From: steve@specializedcpt.com
Sent: Wednesday, February 5, 2020 1:40 PM
To: Lindsay Darden
Subject: RE: administrative special use request for verizon higby stealth tower
Attachments: scan0322.pdf

RE: Administrative Special Use Request for Verizon Higby Stealth Tower

File: AL-19-025
Parcel ID No.:6100000298

SHEET TITLE: **SITE PLAN & SETBACK SITE PLAN**

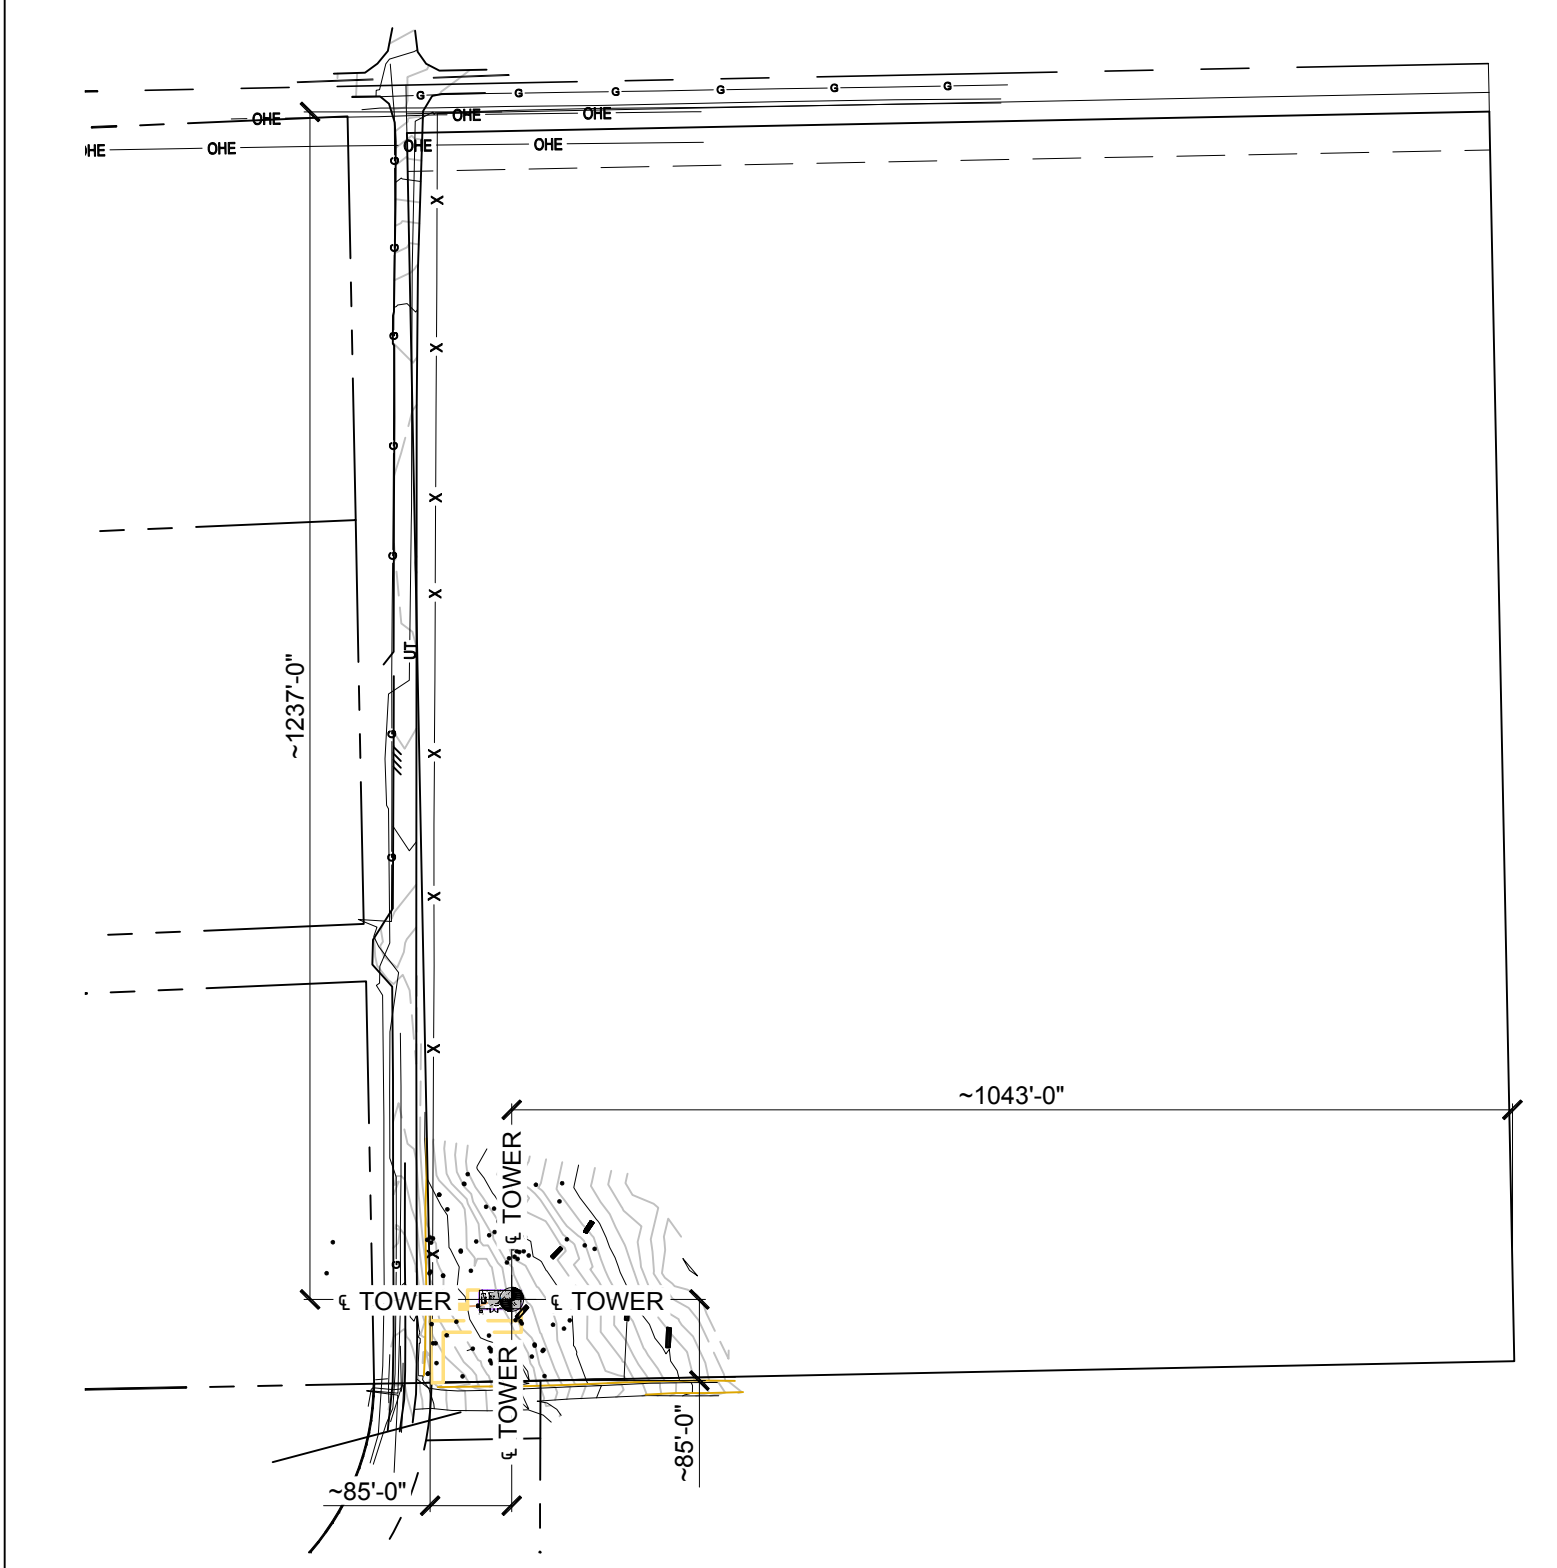
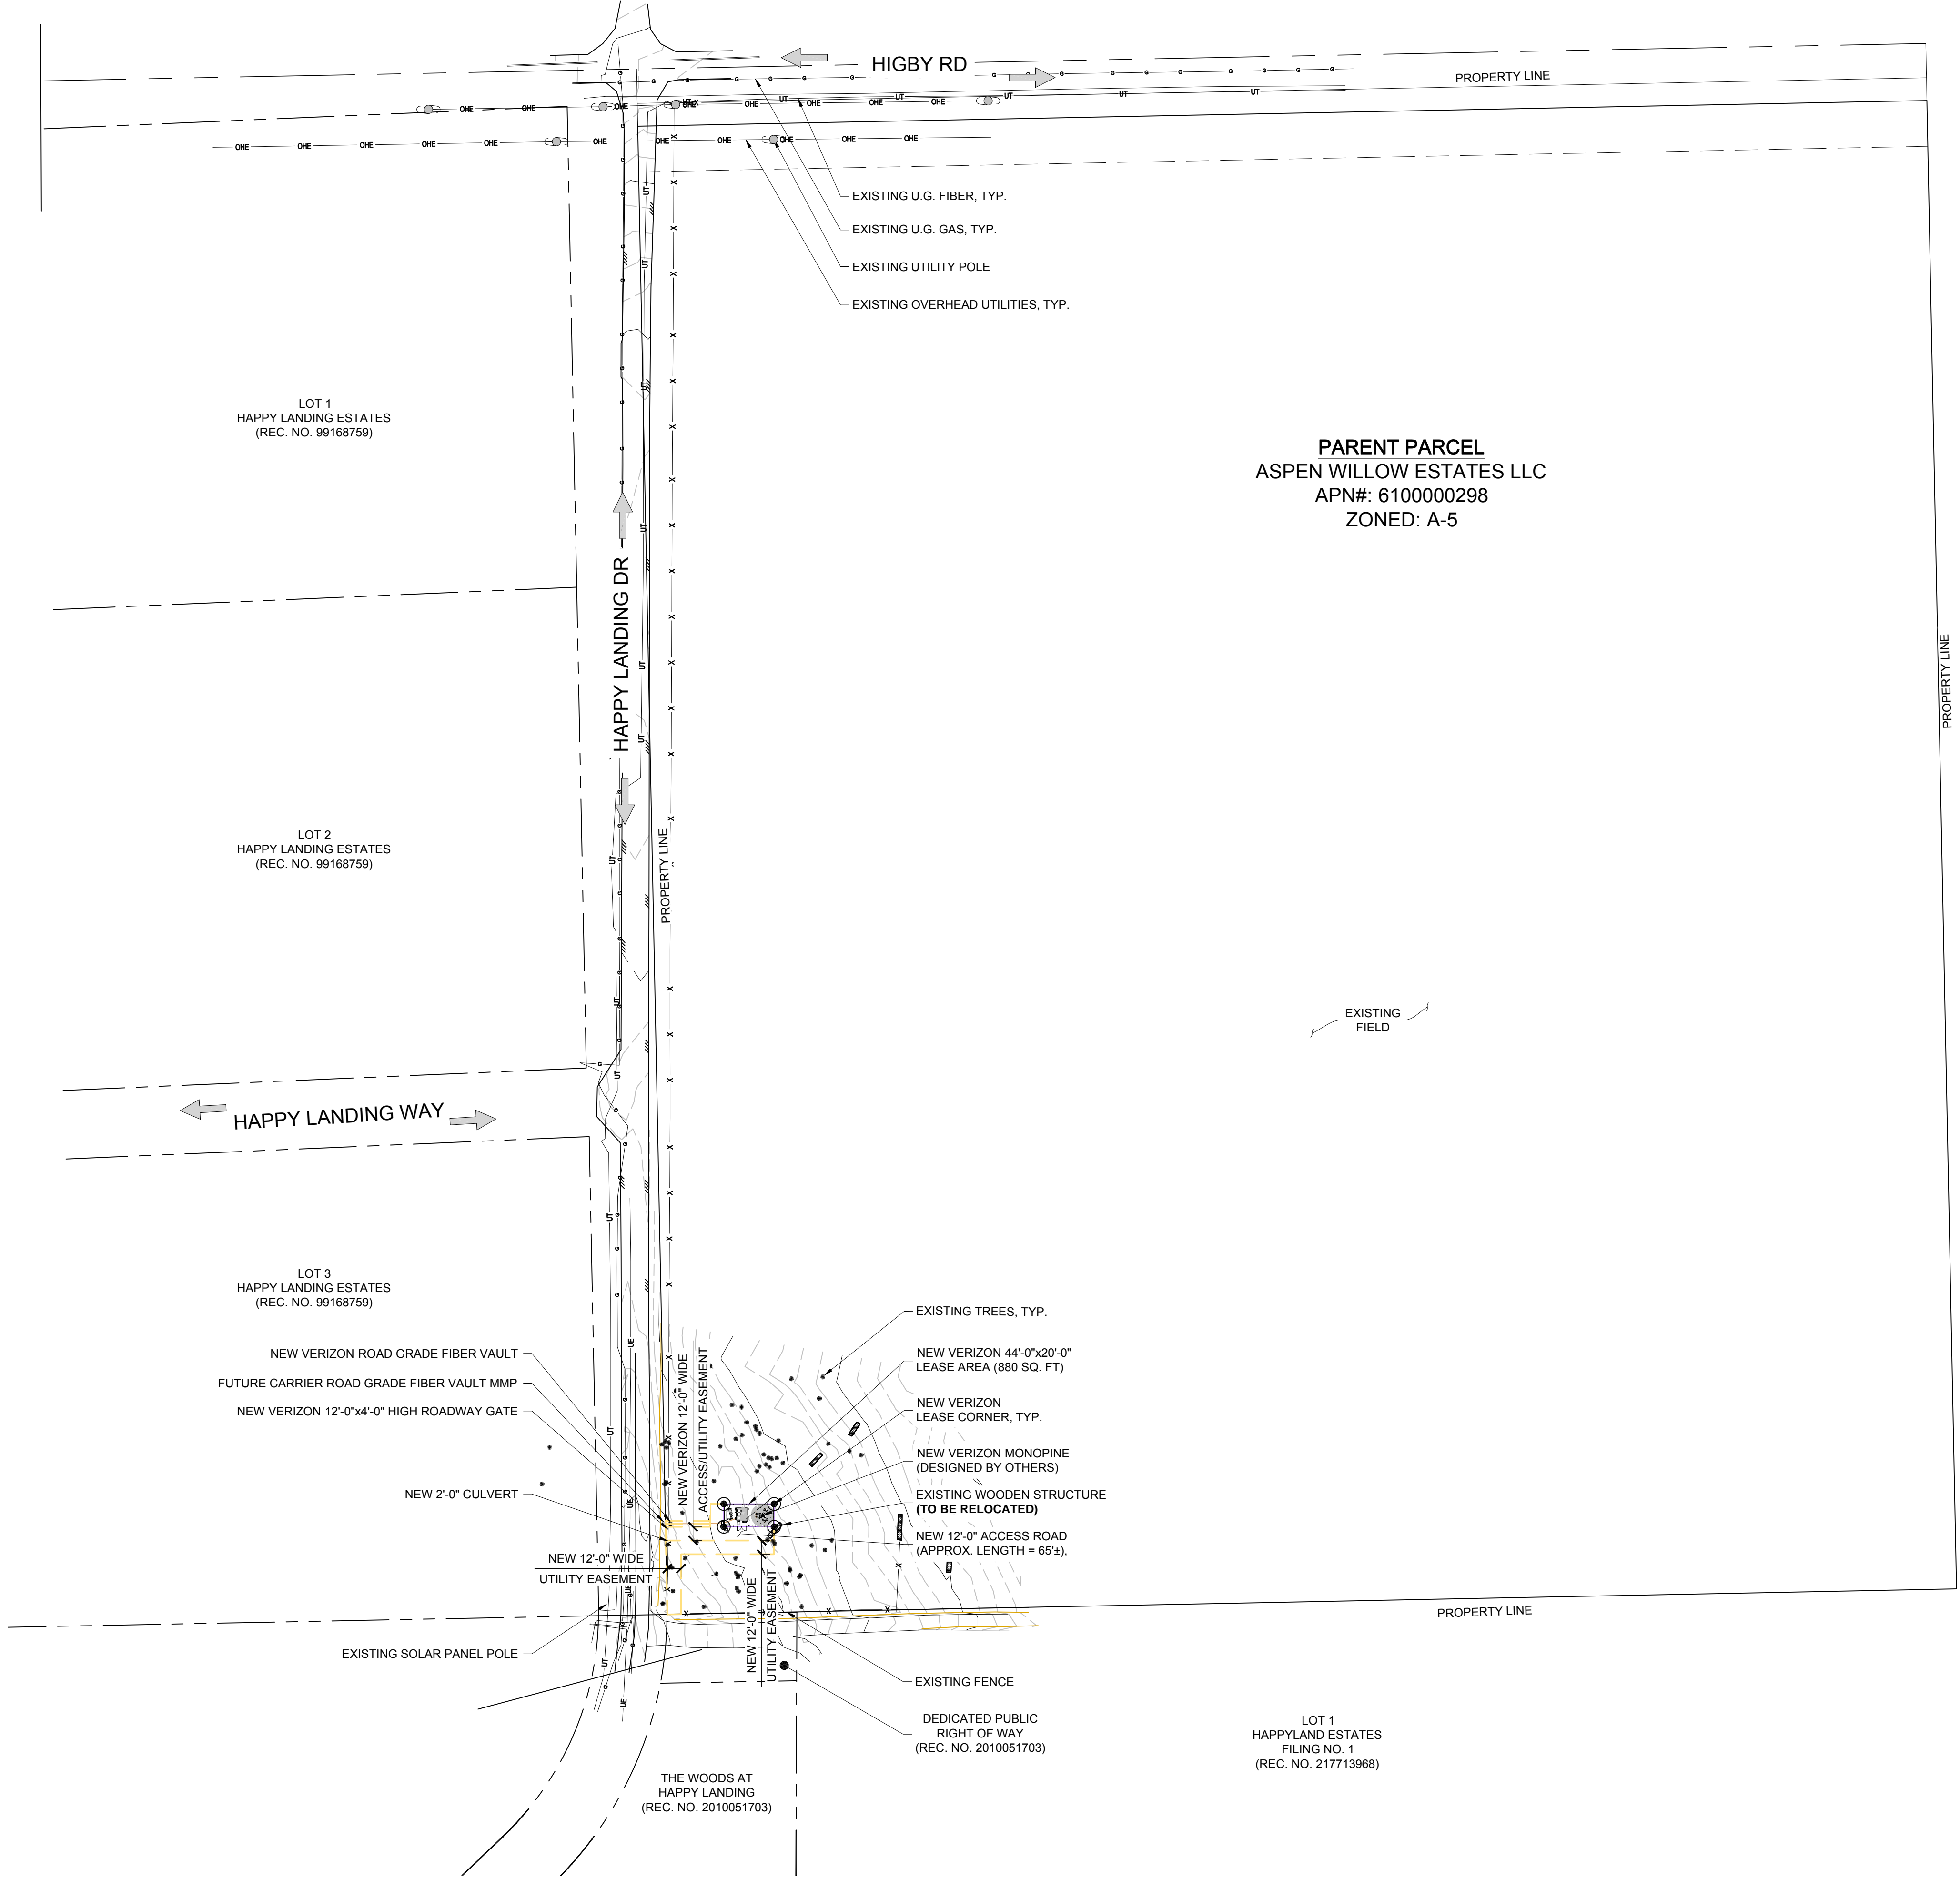
We object to the location of the tower as it is too close to the Higby Estate Residential area. We would propose that it should be relocated to another area. Attached on exhibit ‘A’ is a location that looks like from the aerial, obtained from Google Earth, a utility building. Please look into the possibility of this area being used. If it is owned by the city, then that may be advantages to the city as well. It seems as if there are no residential homes in that area, like there are near the current selected location.

In the event that the planning board would like to see the tower built on the proposed property, it should be done so at the very southeast corner so as to have the least impact, if any, on the residential neighborhood. Please see attached exhibit ‘B’.
